**WELWYN HATFIELD BOROUGH COUNCIL  
ASSISTANT DIRECTOR (PLANNING)**

**DELEGATED APPLICATION**

**Application No:** 6/2023/0657/HOUSE  
**Location:** 9 South Drive Cuffley Potters Bar EN6 4HP  
**Proposal:** Erection of the front porch  
**Officer:** Ms Kirsty Shirley

**Recommendation:** Refused

TITLE:
 Front and Rear Elevations

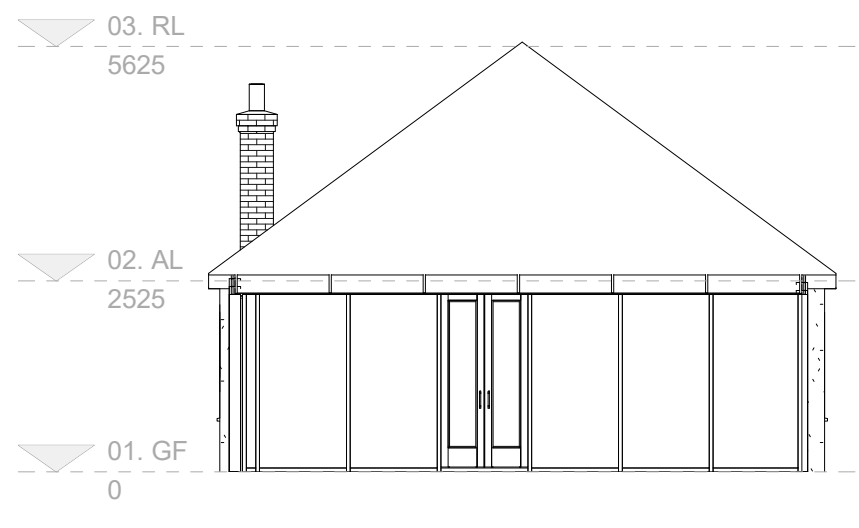
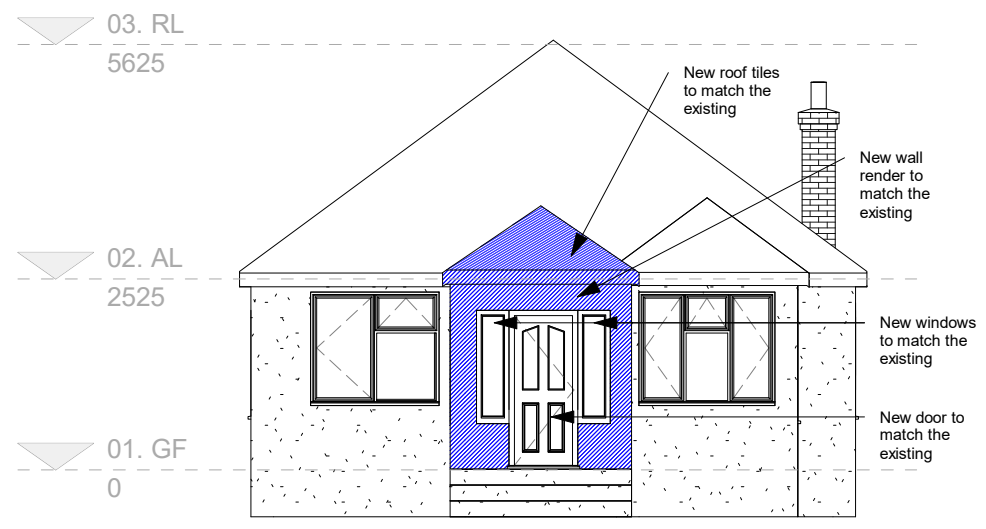
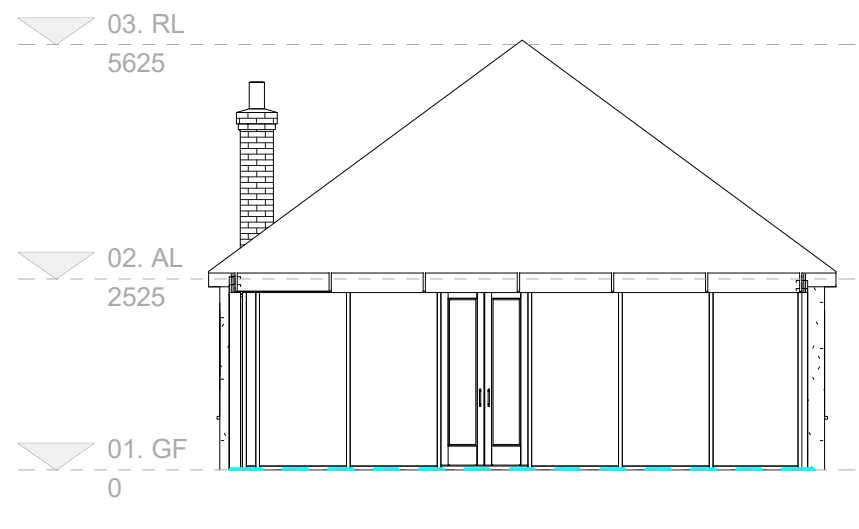
<p>design an extension that matches and complements the existing building.</p> <p>Paragraph 126 of the NPPF clearly advises that the creation of high-quality buildings and places is fundamental to what the planning and development process should achieve, and that good design is a key aspect of sustainable development. At paragraph 130, the NPPF further advises that decisions should ensure developments will function well, be visually attractive, sympathetic to local character and establish a strong sense of place.</p> <p>Paragraph 134 is clear that <i>“Development that is not well designed should be refused, especially where it fails to reflect local design policies and government guidance on design, taking into account any local design guidance and supplementary planning documents such as design guides and codes.”</i></p> <p>The proposal is for a front porch. The front porch would feature a hipped roof and the porch would extend slightly beyond the projection of the front facing bay window.</p> <p>The ridge of the hipped roof of the porch would be in alignment with the ridge of the hipped roof of the bay window. The front porch would project slightly further than the existing bay window and the side roof slopes of the hipped roof would be larger than those of existing front facing hipped roof.</p> <p>The proposal would introduce a further front facing hipped feature within the roof slope of the existing dwelling. While hipped features are predominant within the area, the secondary hipped feature would detract from the primary hipped feature of the dwelling by virtue of a competing scale and positioning. Furthermore, the proposal would result in the removal of the characteristic bricked archway. The positioning and design of the proposal would therefore result in undue harm to the appearance of the application dwelling as well as detrimentally detracting from the character of the area, contrary to Policies D1 and D2 of the Welwyn Hatfield District Plan; Policies SP1 and SP9 of Draft Local Plan; Policies D1 and D2 of the Northaw and Cuffley Neighbourhood Plan; the Supplementary Design Guidance; and the National Planning Policy Framework.</p>

1. The proposed development, as a result of the positioning and design, would result in undue harm to the appearance of the application dwelling as well as detrimentally detracting from the character of the area, contrary to Policies D1 and D2 of the Welwyn Hatfield District Plan; Policies SP1 and SP9 of Draft Local Plan; Policies D1 and D2 of the Northaw and Cuffley Neighbourhood Plan; the Supplementary Design Guidance; and the National Planning Policy Framework.
